**KIRKLEES METROPOLITAN COUNCIL
INVESTMENT & REGENERATION SERVICE**

DELEGATED DECISION TO DETERMINE PLANNING APPLICATIONS

Reference No:	2026/62/91705/W
Site Address:	42, Thomas Street, Lindley, Huddersfield, HD3 3JJ
Description:	Erection of single storey extension to rear
Recommending Officer:	James Evans

Officer Report – 2026/91705

proposed single storey extension

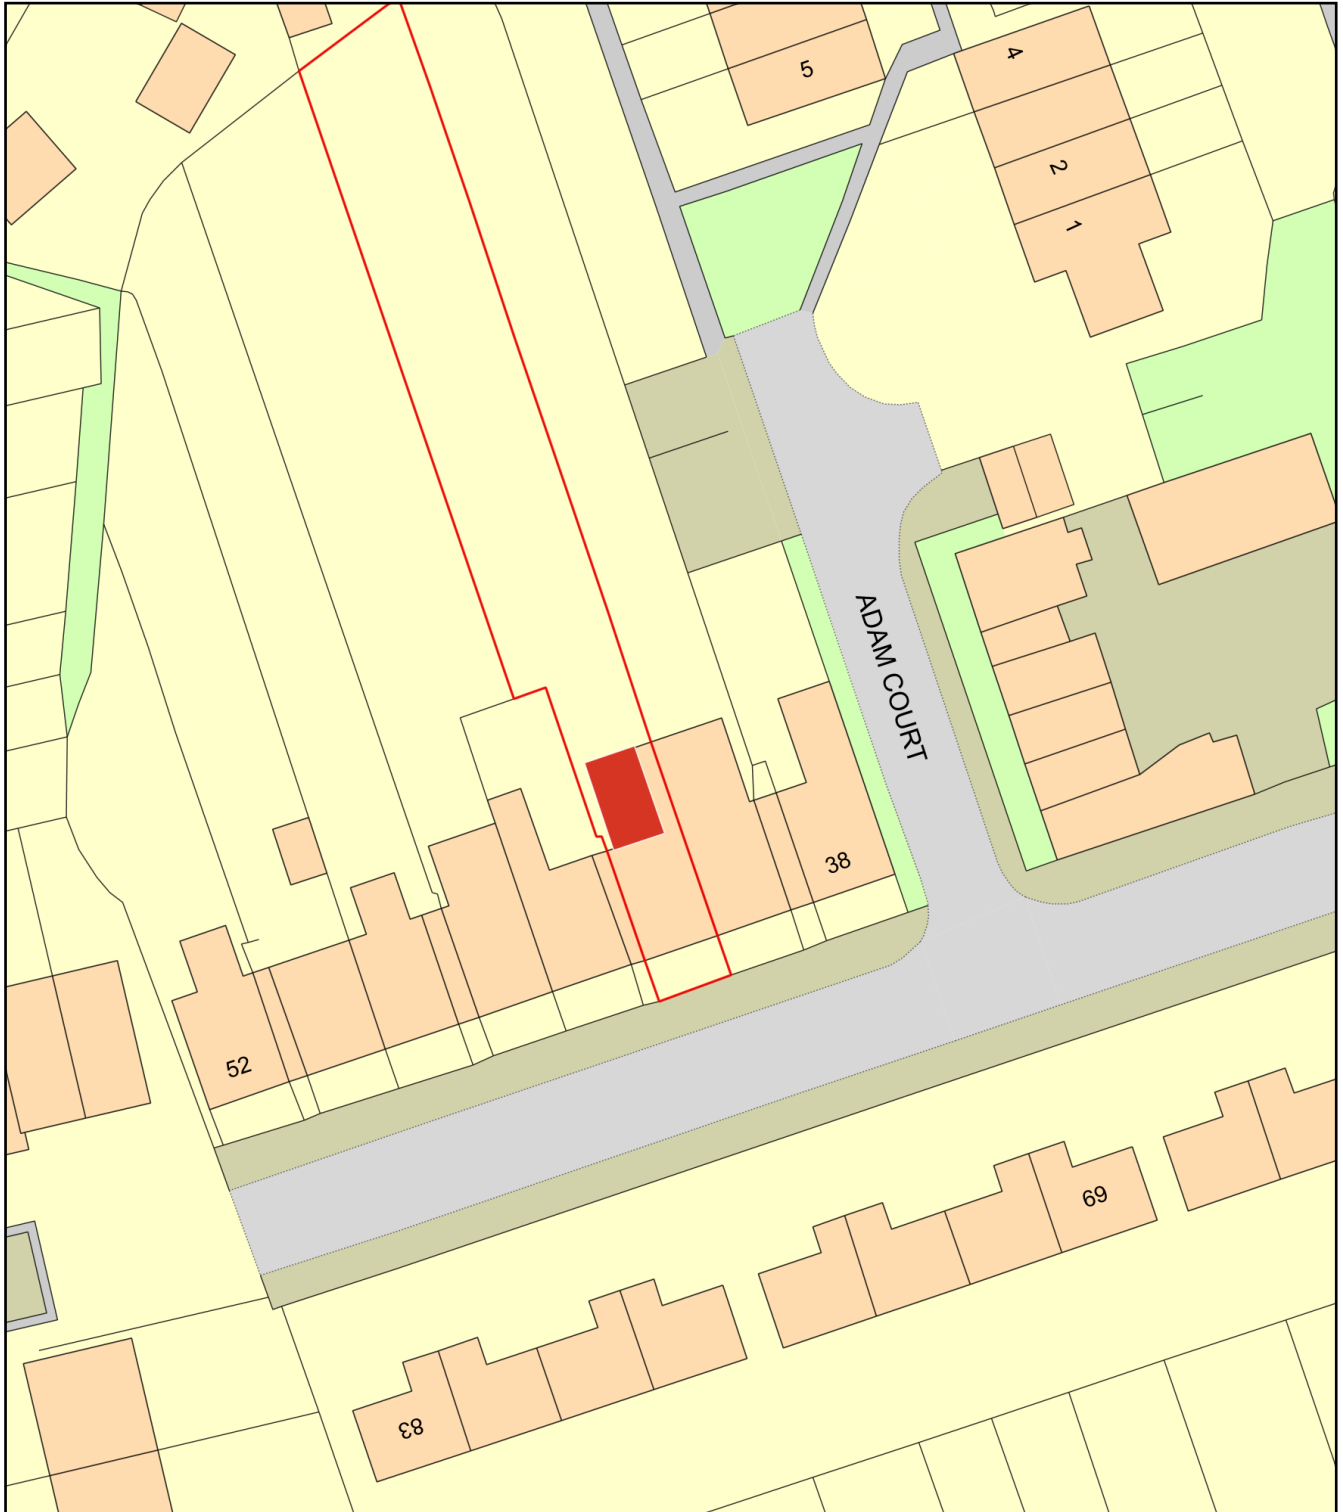
In terms of overshadowing impact, the proposed projection of 5.7m is considered unacceptable as the 45 degree rule is not met from the ground floor window of 44 Thomas Street, which appears to serve a habitable room, and this would lead to an unacceptable loss of light.

In terms of overbearing impact, the proposed extension would also create a boxed in effect, negatively impacting the outlook from the rear ground floor window of 44 Thomas Street. It is noted that planning permission was granted at 40 Thomas Street for a similar rear extension (2012/91464), however the neighbouring property (38 Thomas Street) had not been constructed when permission was granted, therefore this permission provides little weight in the assessment of this application, and cannot be considered to represent a precedent in this instance.

1. The proposal, by virtue of its projection, would result in an unacceptable overbearing and overshadowing impact on 44 Thomas Street, to the detriment of the residential amenity of the occupants of that property. To permit the proposal would be contrary to Policy LP24 of the Kirklees Local Plan, Principles 3, 4, 5 and 6 of the adopted House Extensions and Alterations SPD, and advice within Chapter 17 of the National Planning Policy Framework.
